Planning Application No: 3/2025/0407

Proposal: Proposed extension of rear dormer, new front dormer and new front porch.

Location: 1 Eastfield Drive West Bradford BB7 4TQ

PROPOSED SITE PLAN

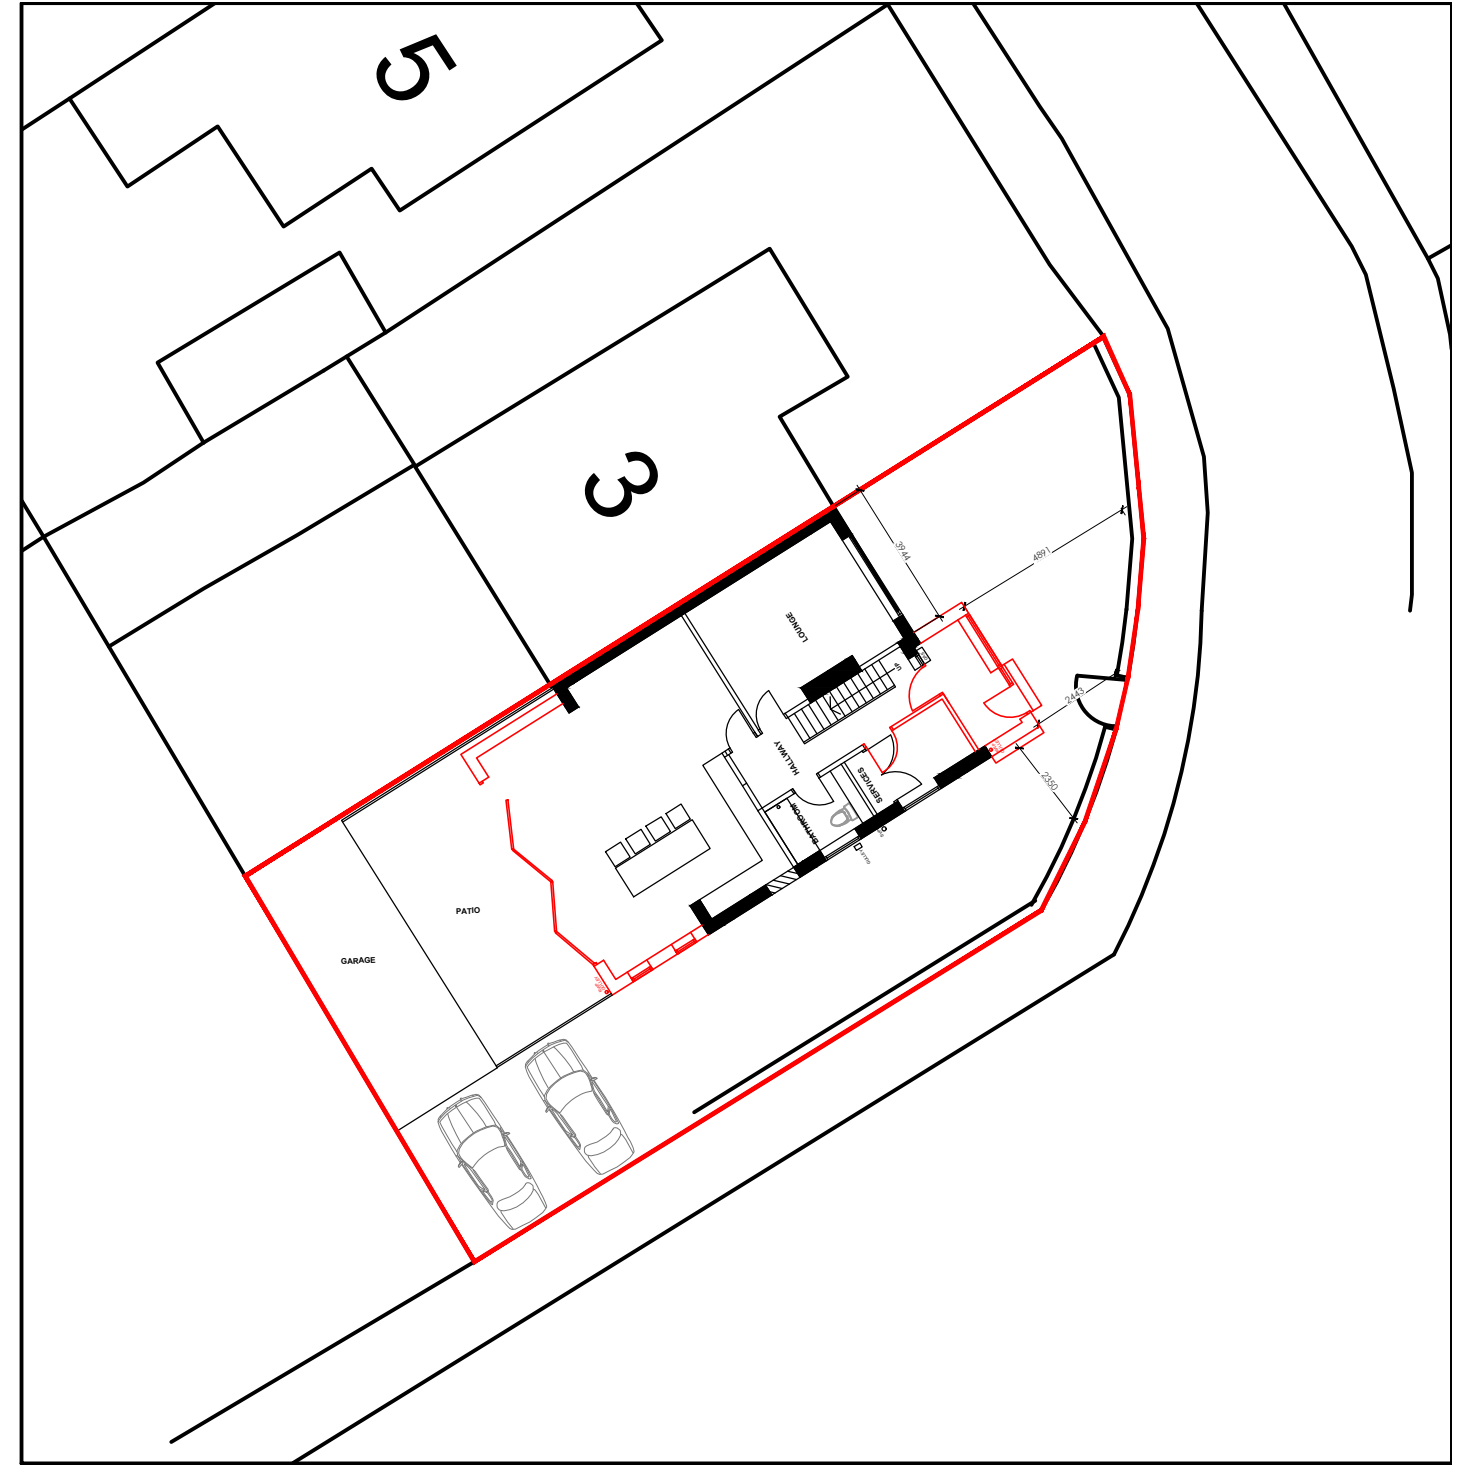
It is noted that there is a loss of a parking space due to this proposal (ref. Existing and Proposed site Plan).

Please provide a parking plan to show the 2 parking spaces required by parking standards can be provided within the curtilage of the dwelling.

PROPOSED SITE PLAN

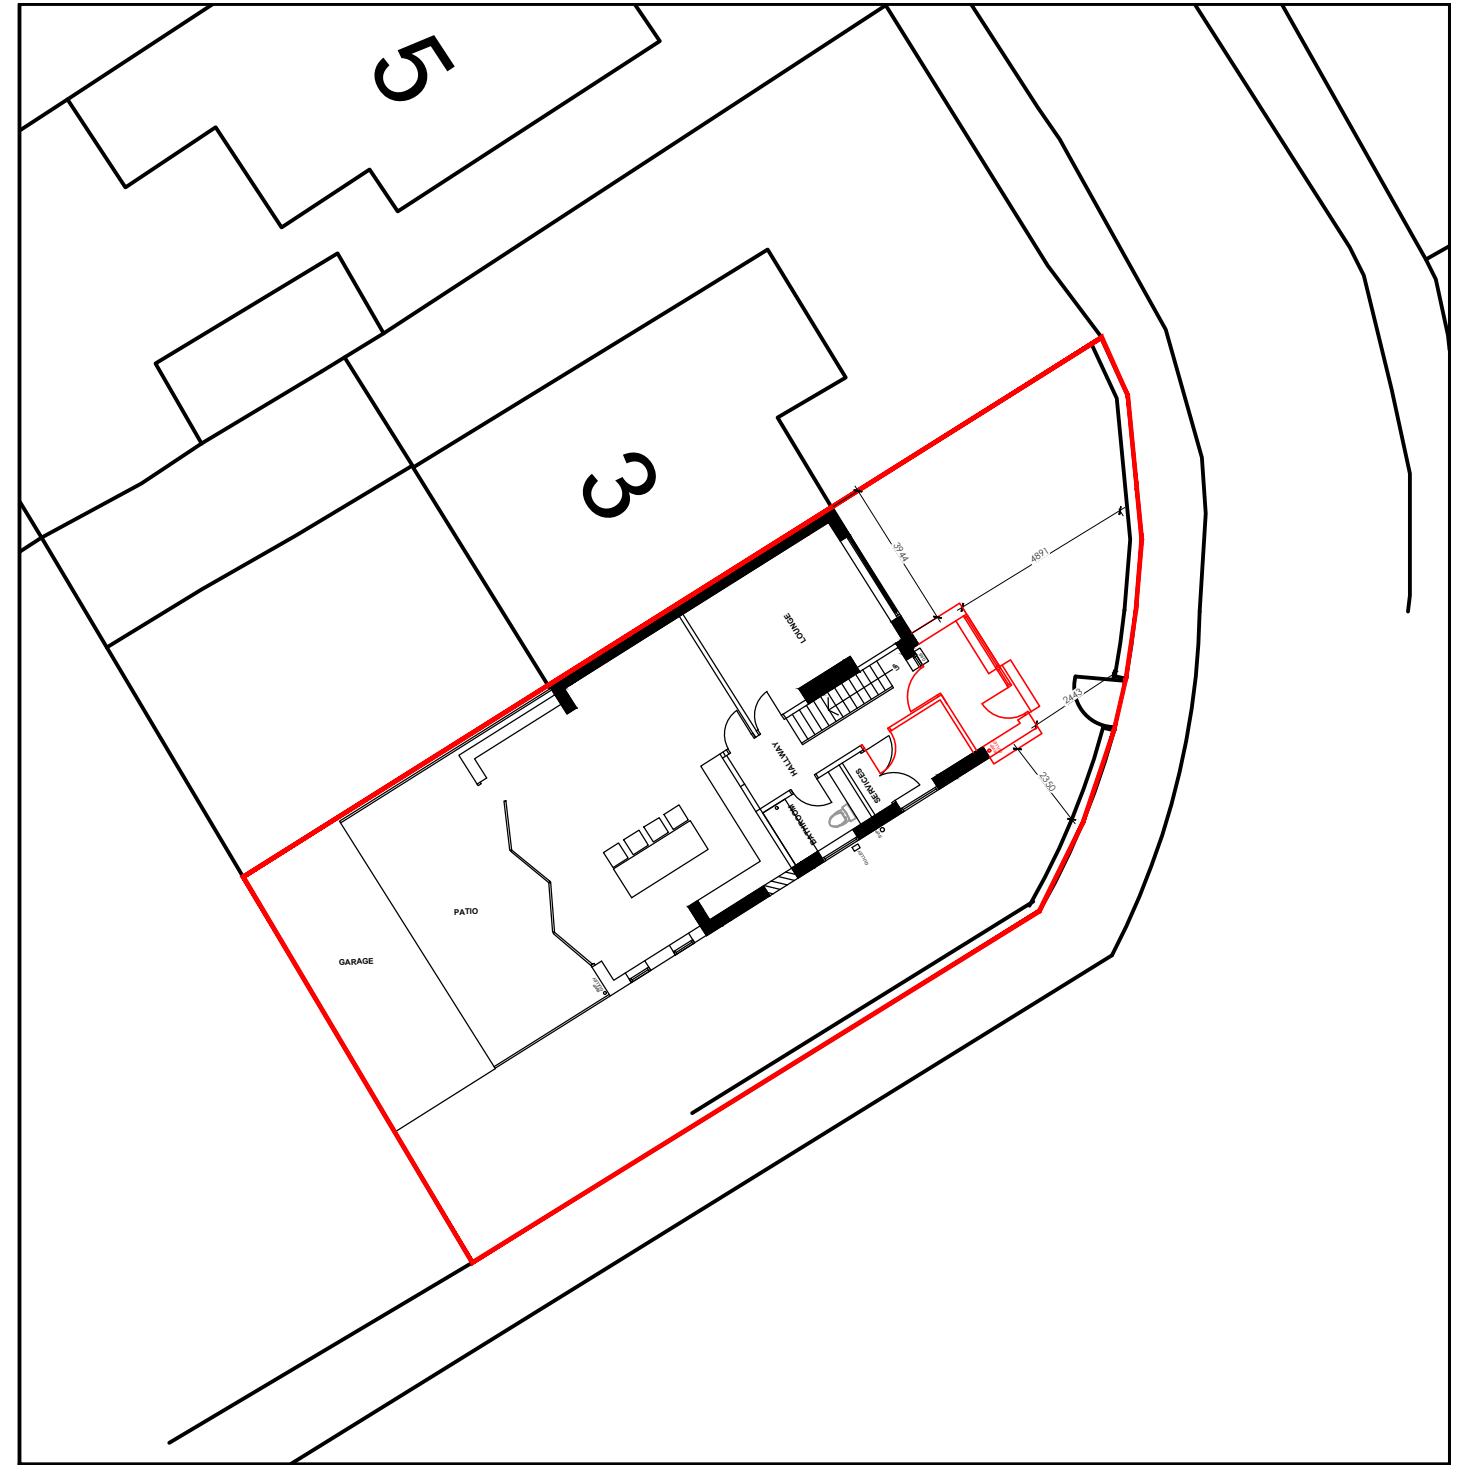
In respect of domestic car parking standards, a garage (3m x 6m) would count as one space subject to the imposition of a planning condition controlling use.

Car parking space should be 2.4m x 4.8m. A minimum of 6 m is required to enable cars to reverse out of a car parking space.
